STERLING RANCH ROAD & BRIARGATE PARKWAY STREET PLANS	H-SCALE	N/A	No.	REVISION	BY	DATE
	V-SCALE	N/A				
	DATE	2/10/22				
	DESIGNED BY					
NOTES & DETAILS	DRAWN BY					
	CRB					
	CHECKED BY					
SHEET	2	OF	32			
JOB NO.		25188.03

STERLING RANCH ROAD &
BRIARGATE PARKWAY STREET
PLANS
TYPICAL SECTIONS

STERLING RANCH ROAD
STA 10+00 TO STA 20+50

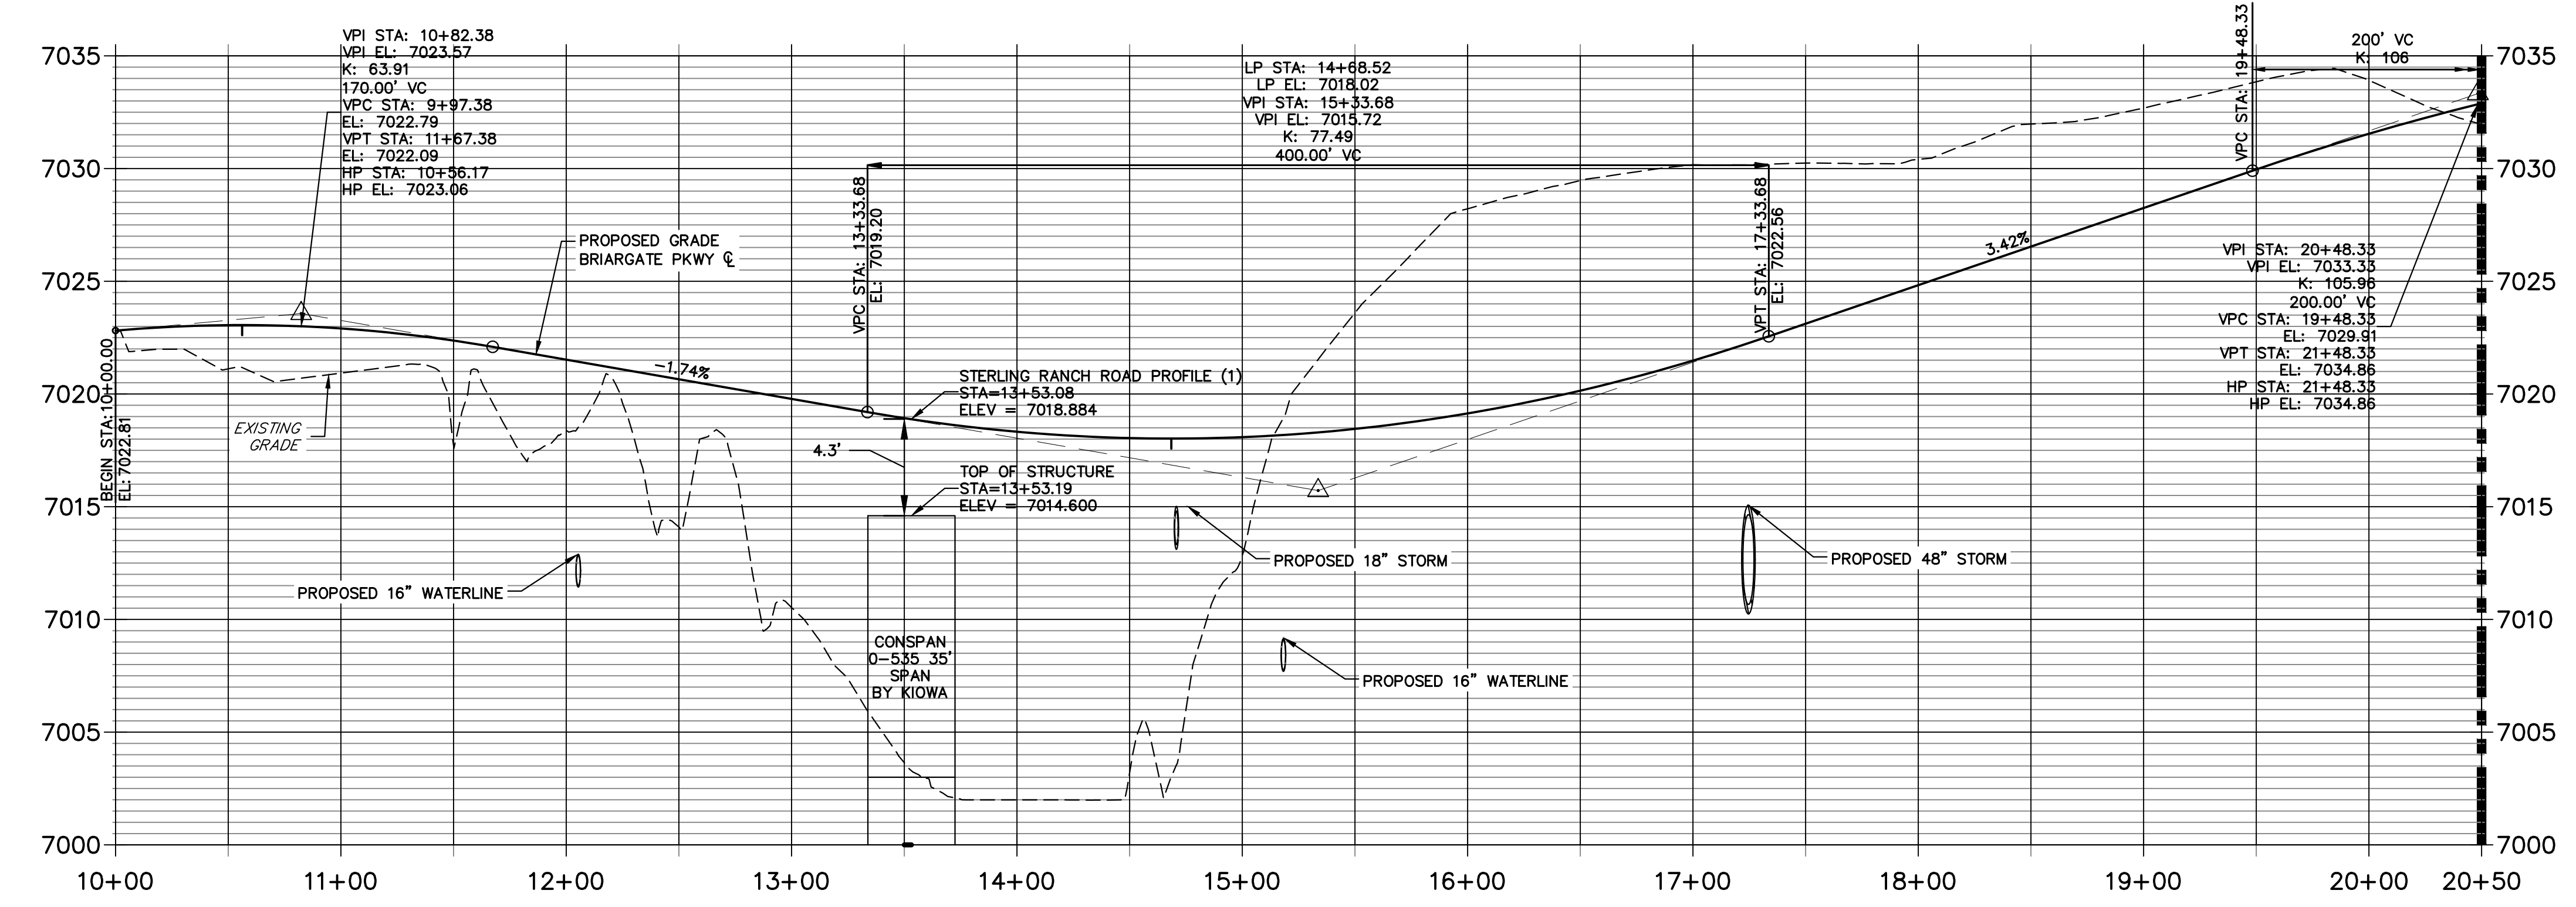
Per ECM Non-residential collector has 5' sidewalk. Please update

**STERLING RANCH ROAD
STA 20+50 TO STA 30+50.00**

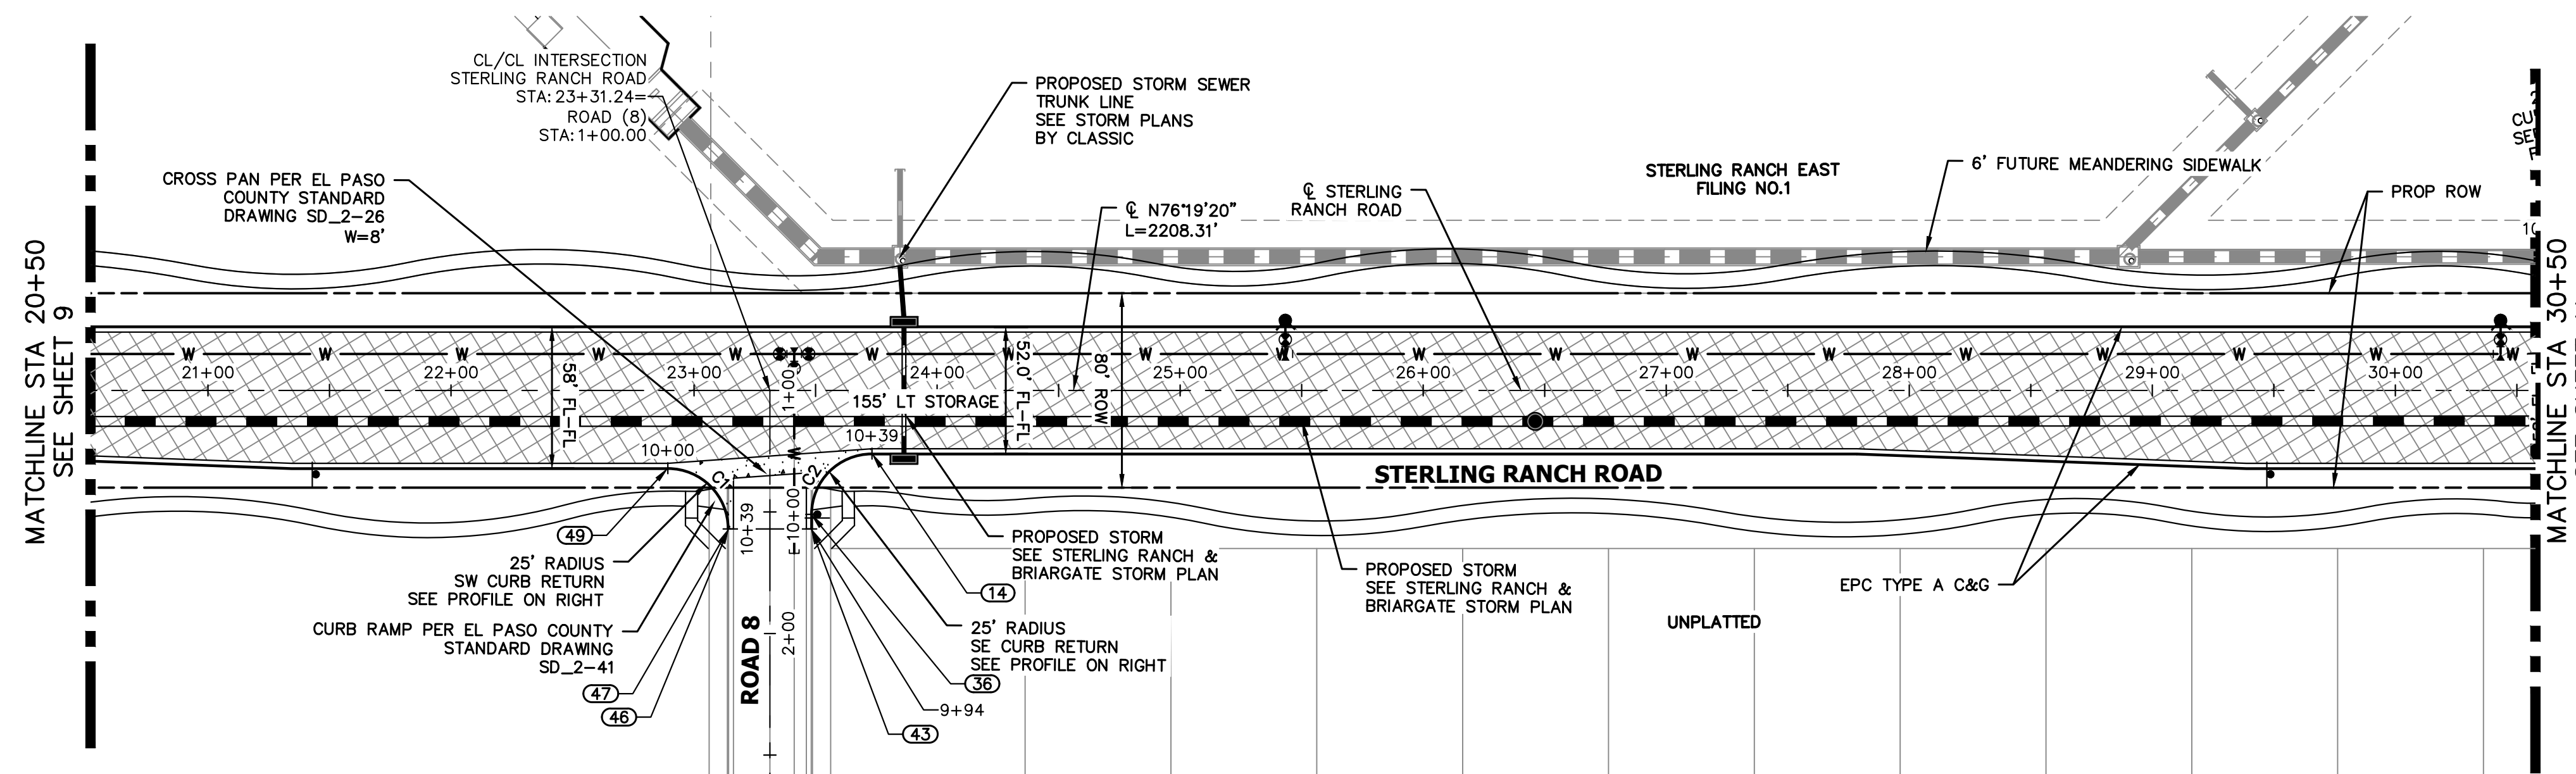
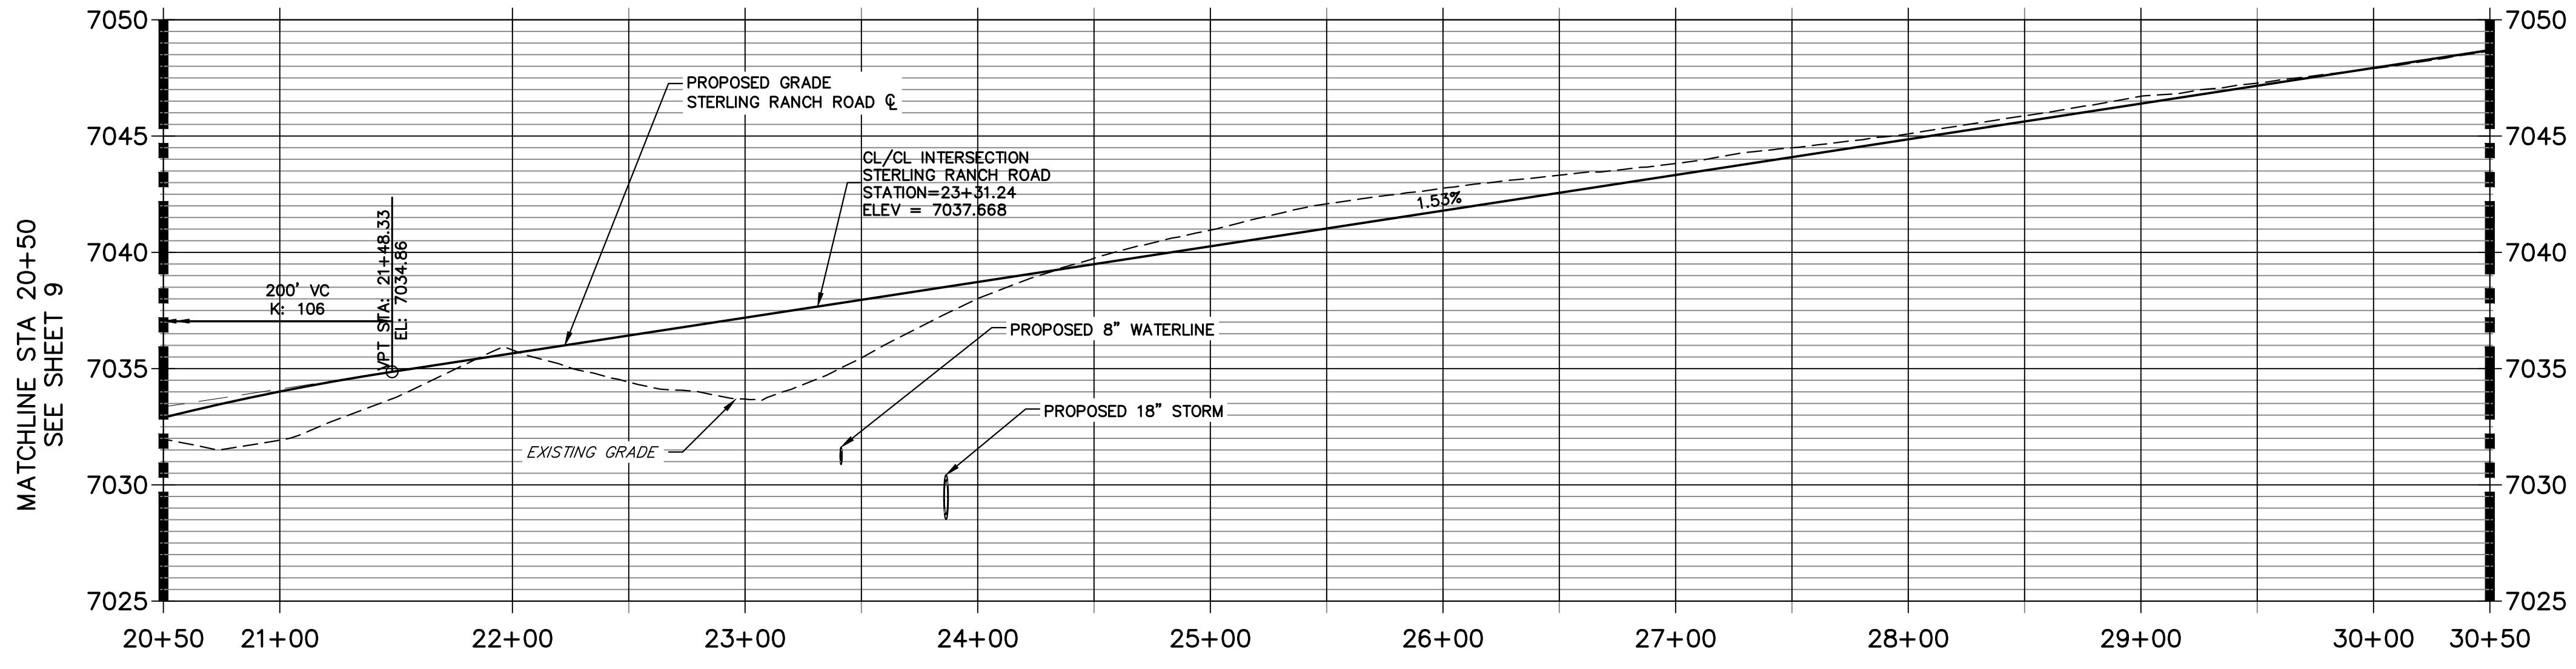
See MUTCD Fig 9C-4 for bike lane striping here
